RE: Project Name File Number: Fowler Creek Guest Ranch (CU-23-00003)  
[Kittitas County Community Development Services | Land Use](#)

We are George and Carrie Menzel and live at 31 Four Wheel Drive, Cle Elum. We are submitting this notice of opposition to the project "Fowler Creek Guest Reach" for consideration.

FOWLER CREEK GUEST RANCH
EXHIBIT 12
EMERGENCY INGRESS AND EGRESS PLAN

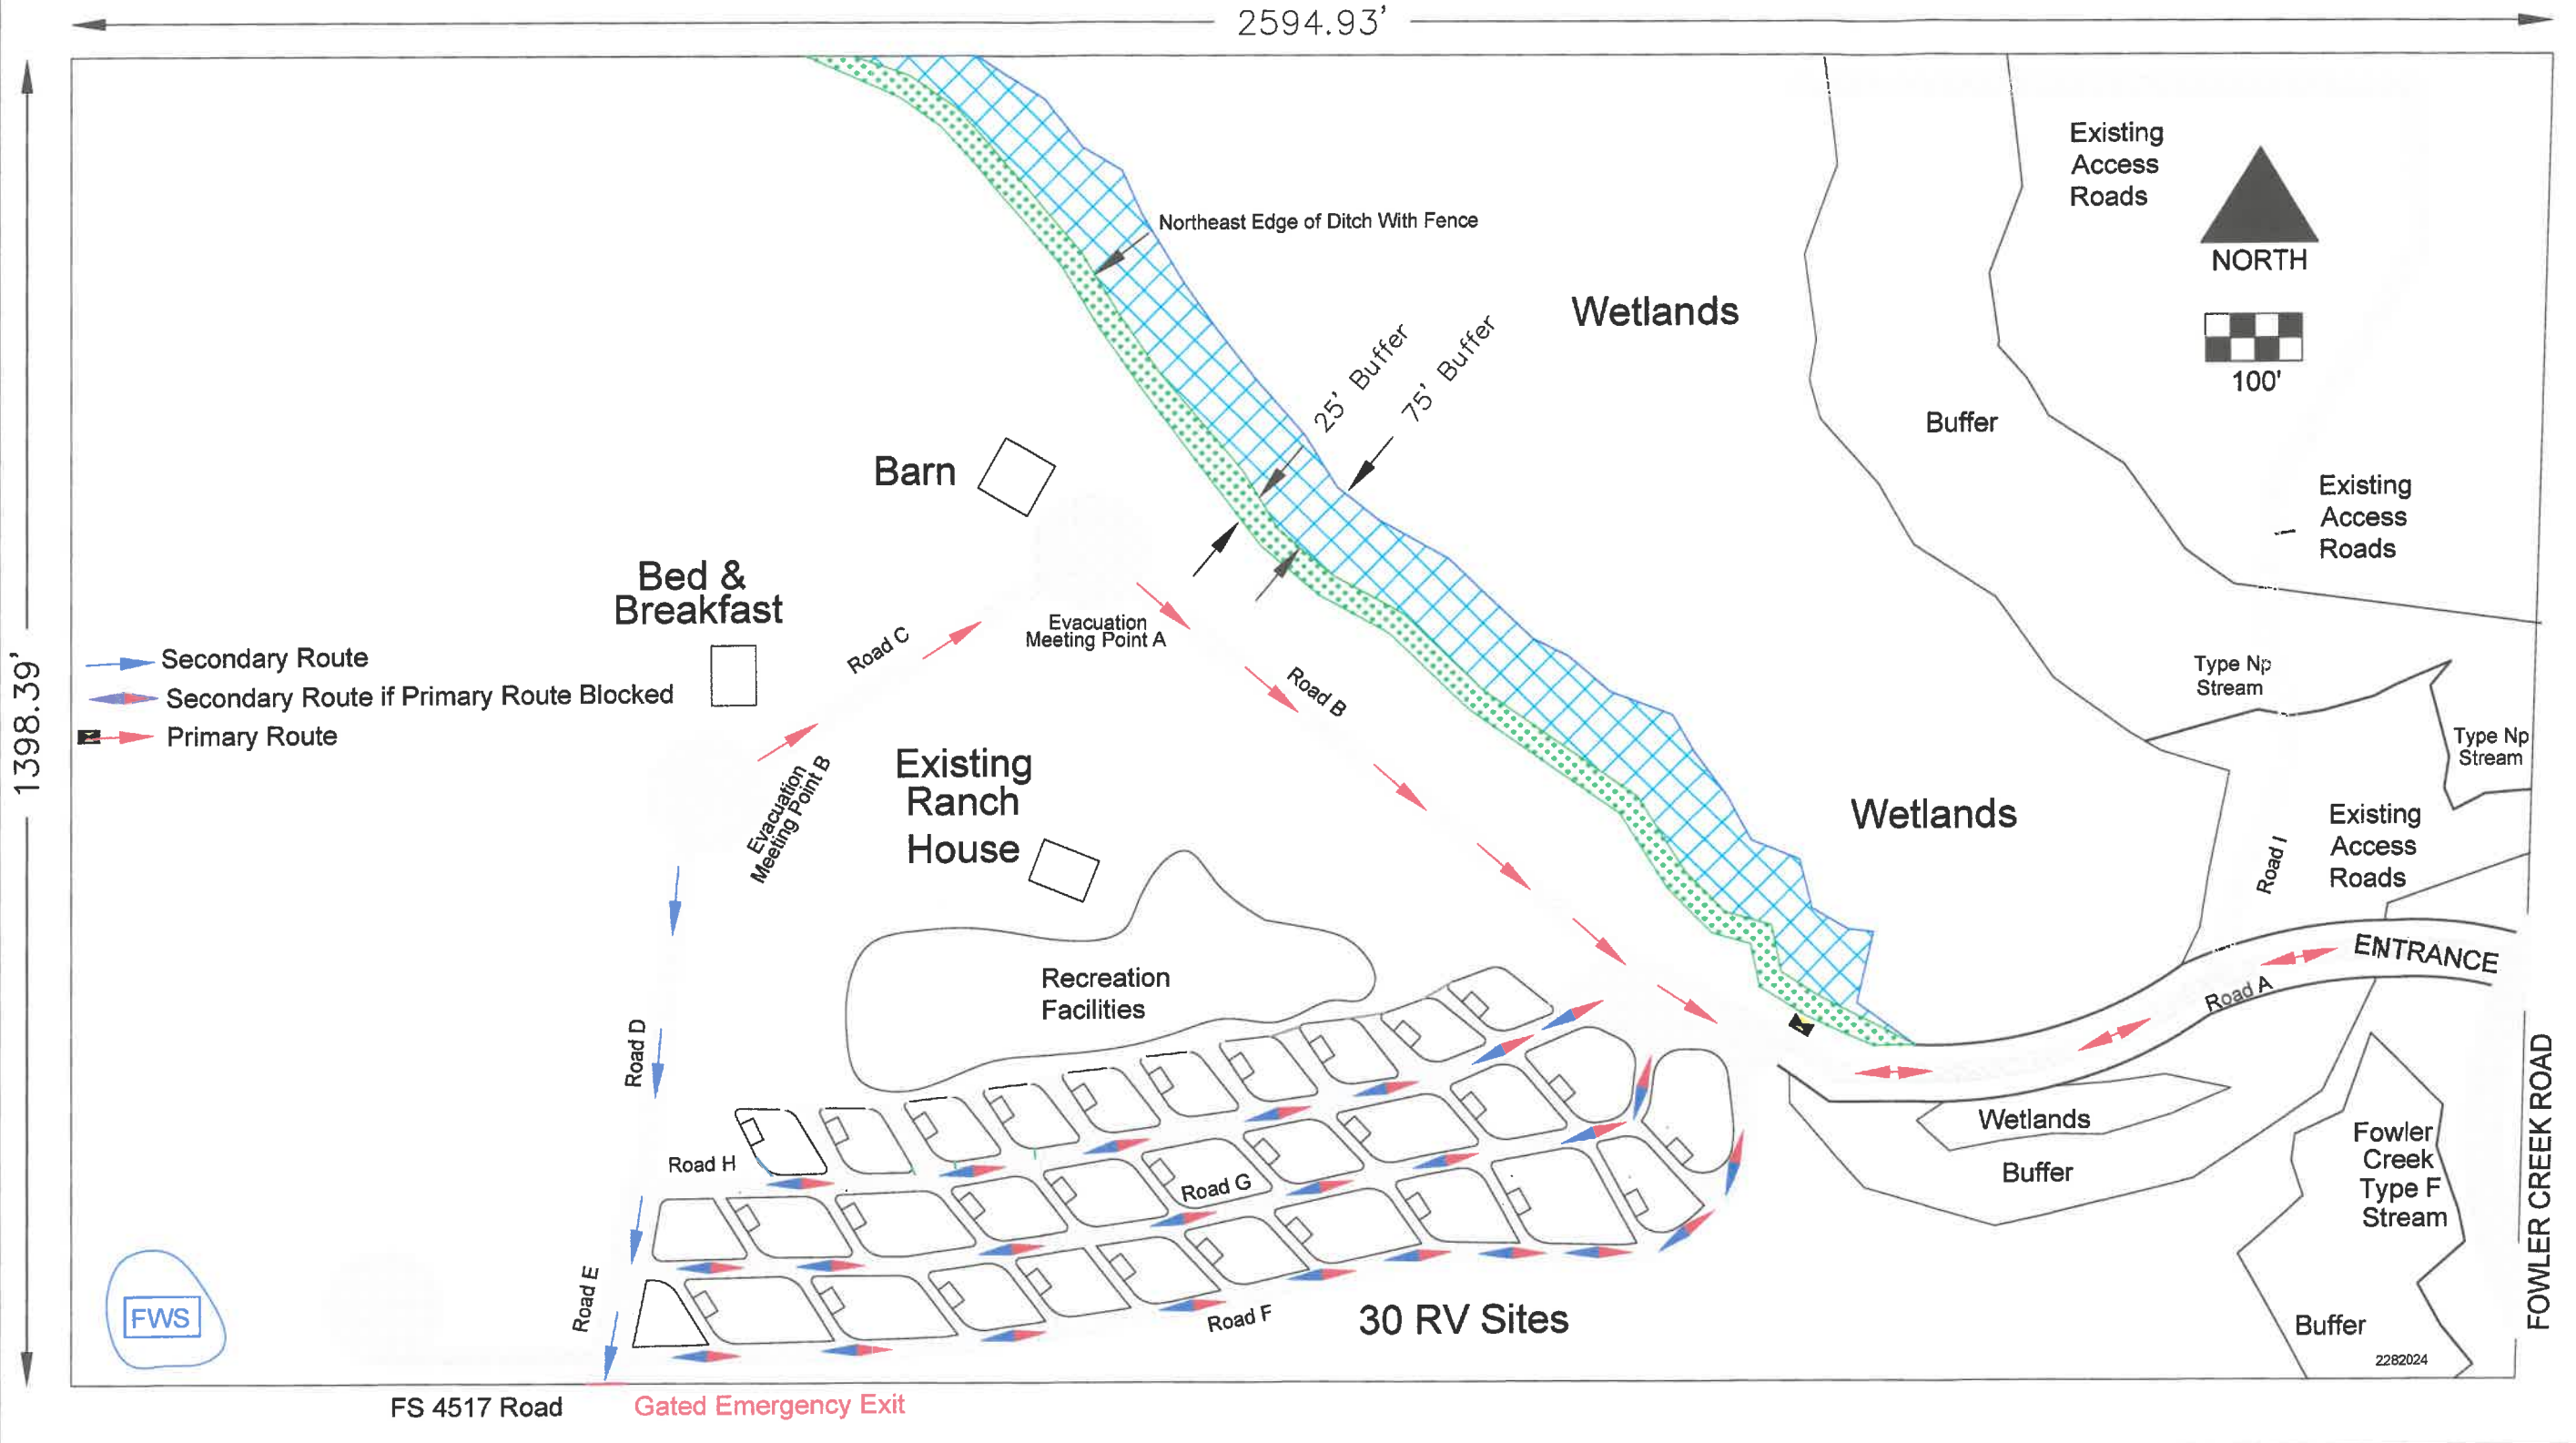
The emergency response, while sufficient to support the estimated <100 residents of the surrounding neighborhood, is not equipped to support the need, timeliness, and size of potential emergencies that a site with 200+ guests could need. In addition, the road defined as an 'Exit' in the plan, falls onto FS RD 4517, a maintenance level 2 road with no provisions for road improvements or upgrades.

- Apply the code as intended and described, and deny application for Land Use under **KCC 17.30A.010**
- As a condition prior to occupancy, require that the Forest Service upgrade the level of service to a level 4 on Forest Service Road 4517 with maintenance paid for on behalf of the proposed Resort or by USFS
- As a condition prior to occupancy, require the creation of an emergency egress road to Westside Rd or Zrebiec Rd

The Fowler Creek Guest Ranch development proposal shares a border and main roadway with my community. The following site map submitted by the developer clearly shows that there will be an official Exit from their Ranch onto FS 4517 Rd. Even though verbally it has been said by the developer that it's only an emergency exit.
